Components Division
Dunn NC #2383
200 Emmett Rd, Dunn NC 28334
910-892-8400

10/14/22

After reviewing the information, this letter is to address the roof trusses for the KB Homes job, Lot 110 Birchwood Grove.

Job 238_2338_C	Truss A3	Truss Type COMMON	Qty 1	Ply 1	KB Home 238.2338.C	144252909
-------------------	-------------	----------------------	----------	----------	--------------------	-----------

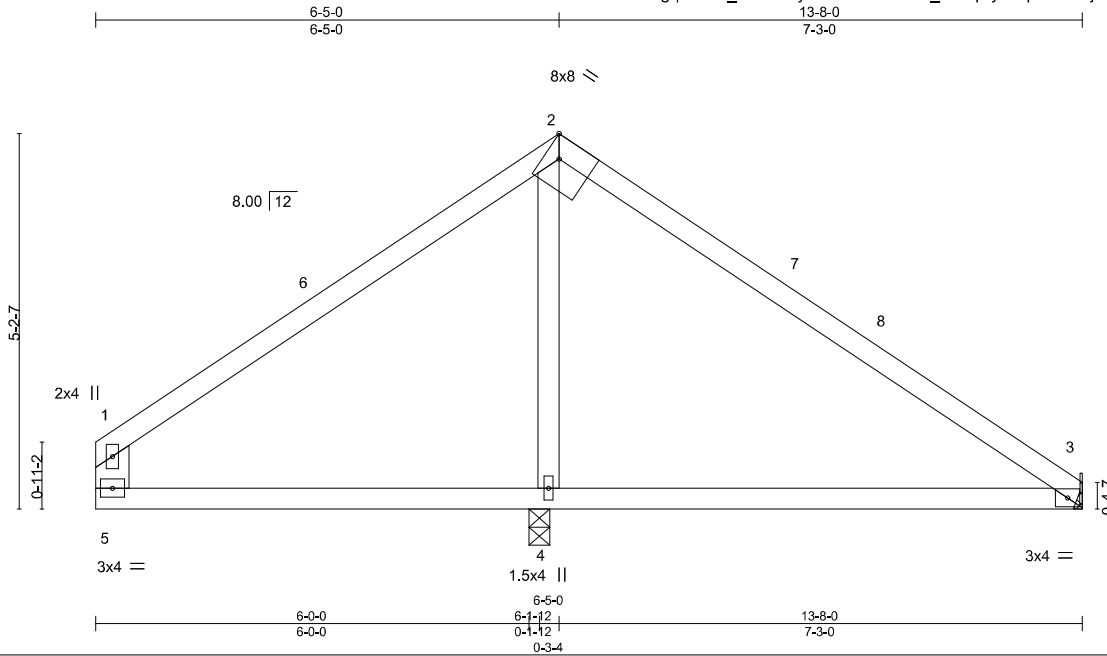
In reference to the A3 truss installed in reverse. This truss will perform as designed with the improper installation. Please feel free to reach out if you have any questions or concerns.
